**ENVIRONMENTAL ASSESSMENT FOR DEVELOPMENT OF MIRANDA DENTAL  
HOSPITAL AT NO. 84-86 KIORA ROAD, MIRANDA**

I refer to the Department of Planning & Infrastructure's letter dated 12 December 2011 (Ref: MP11\_0009) with regard to the abovementioned project application, which was referred to the Roads and Maritime Services (RMS) for comment.

13 February 2012

basement floor plan
scale: 1:100

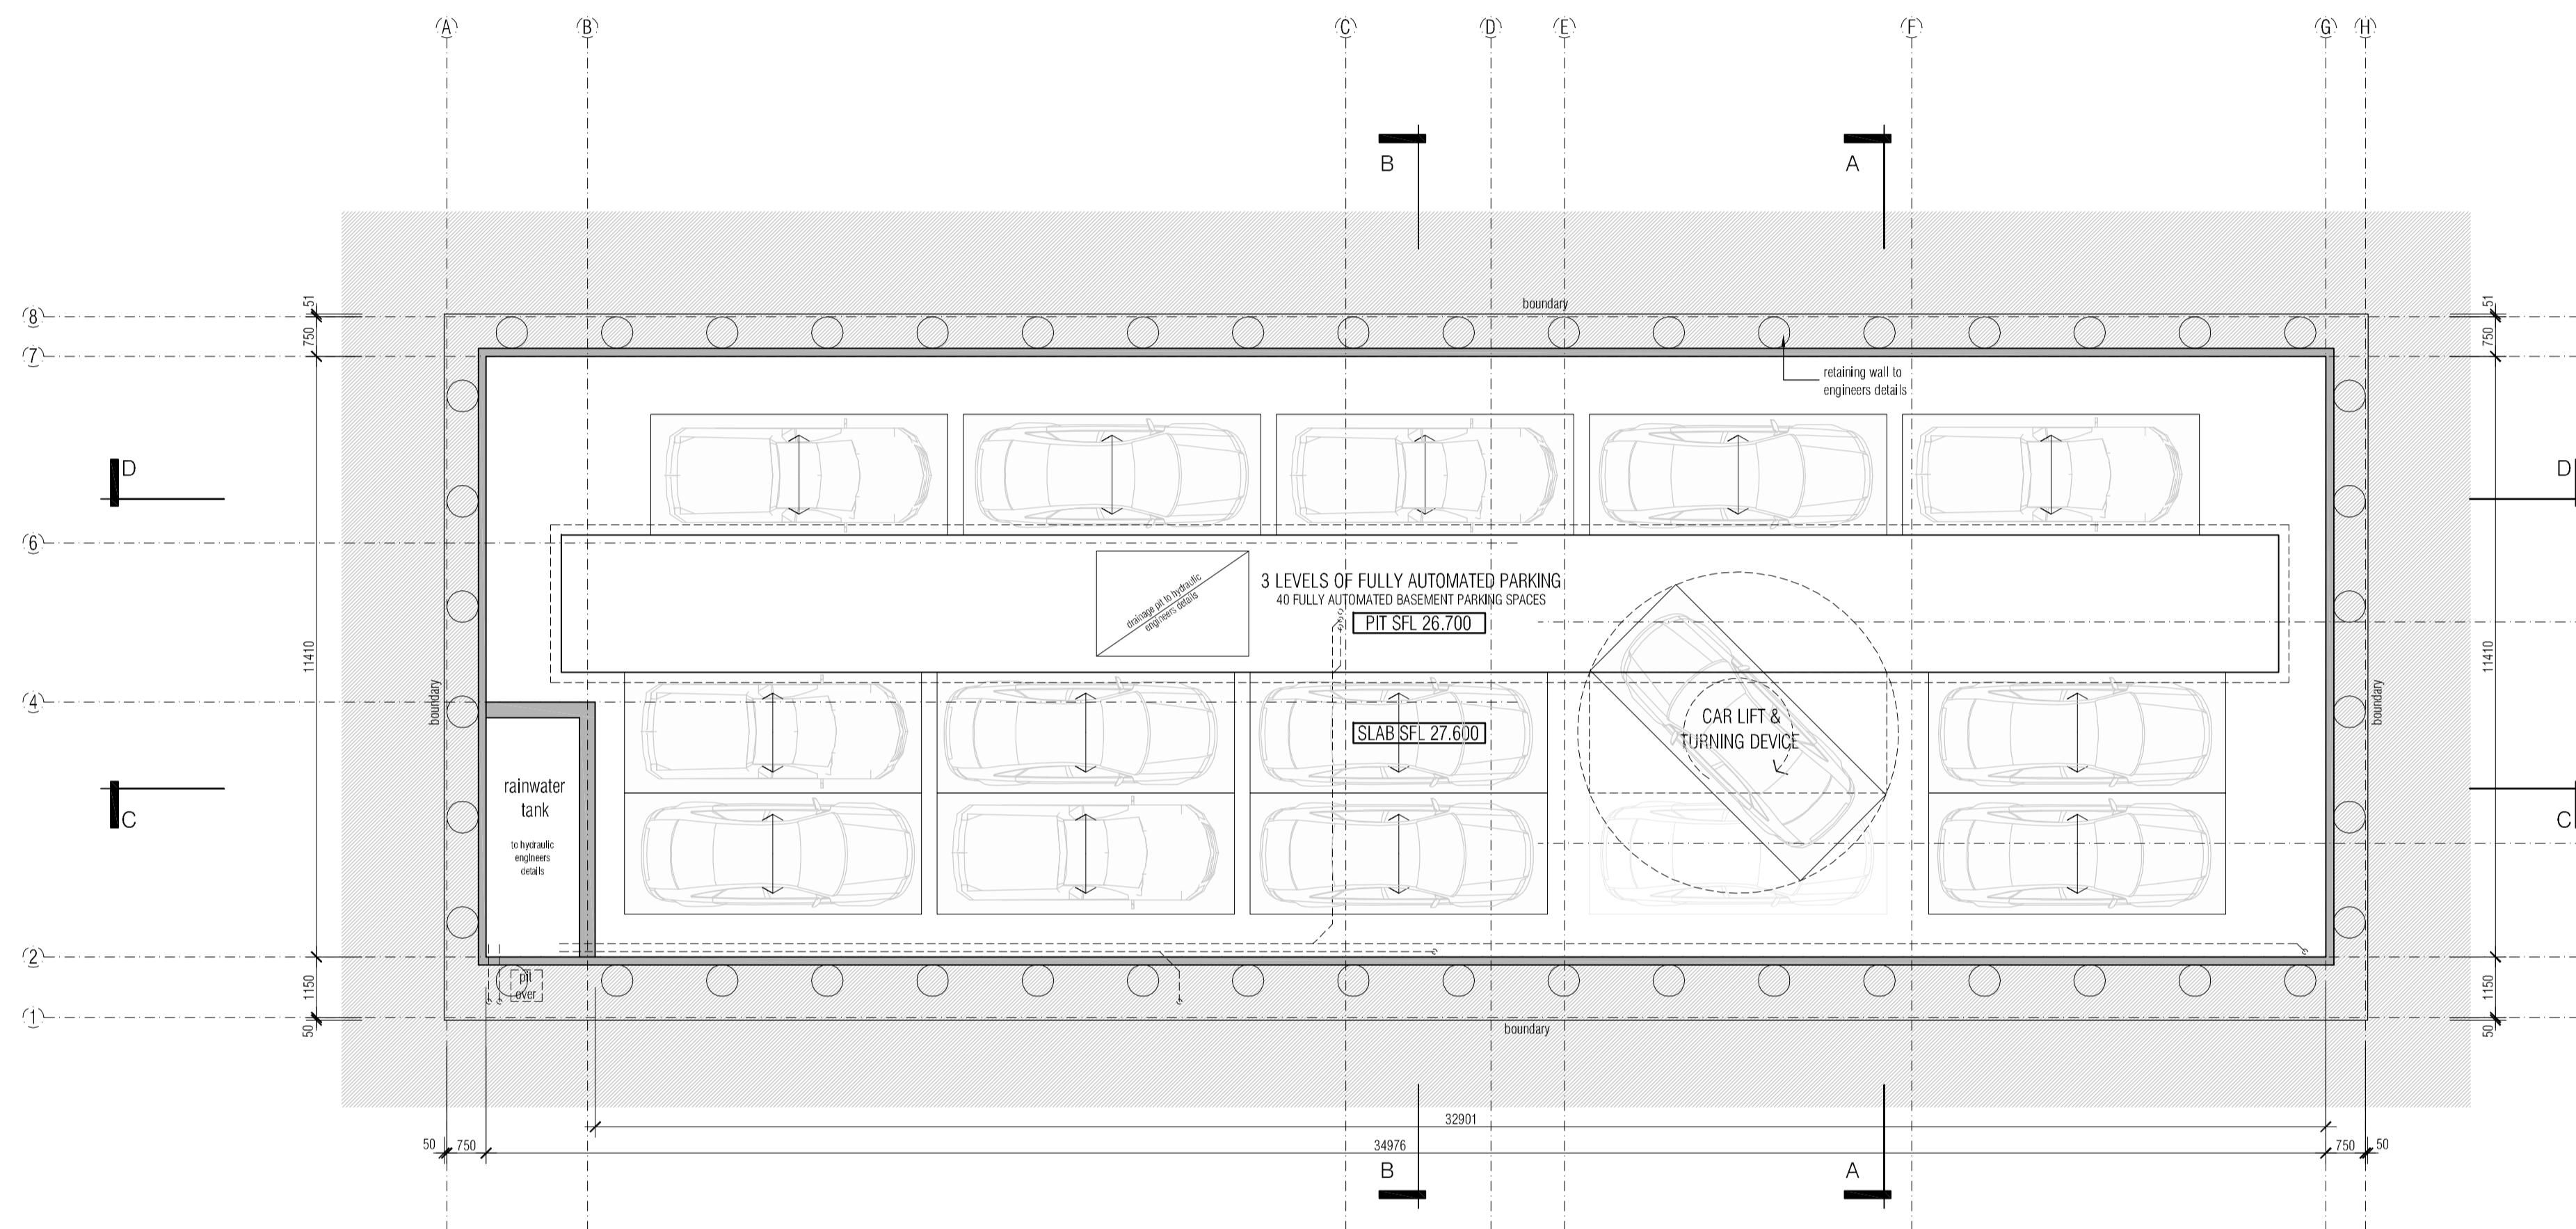
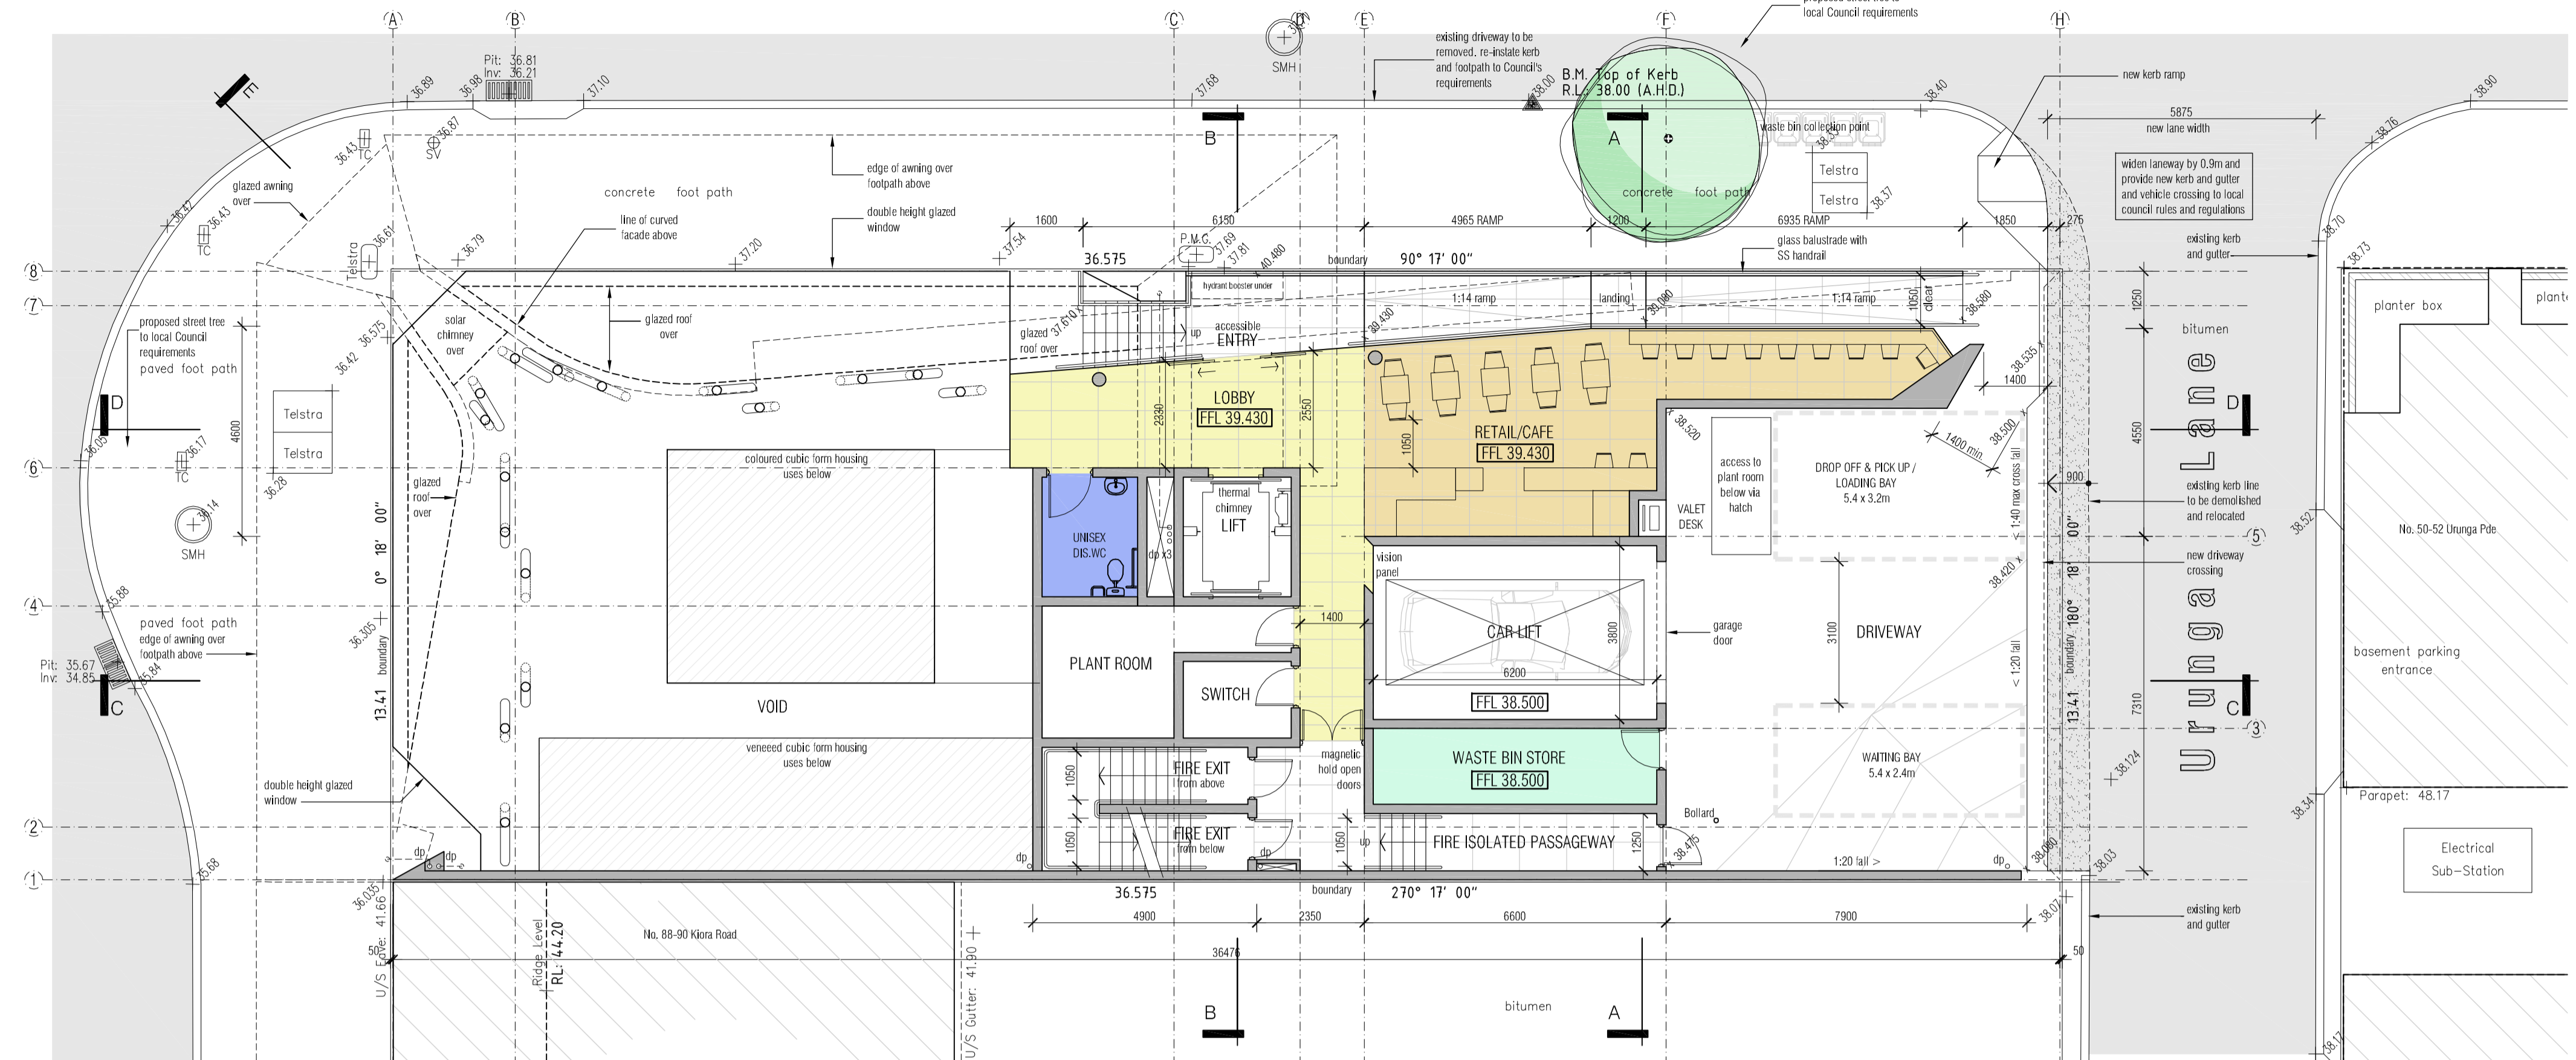
1. Prior to the Occupation Certificate being issued, an on-site Management Plan should be submitted for Council review with regard to the proposed on-site parking arrangements, particular with regard to the management of the car lift.
2. It is noted that the applicant proposes sharing the disabled parking space with the driveway access. This shared arrangement should be certified by a qualified access consultant.
3. All vehicles shall be able to enter and exit the site in a forward direction.
4. All works associated with the proposed development shall be at no cost to the RMS.
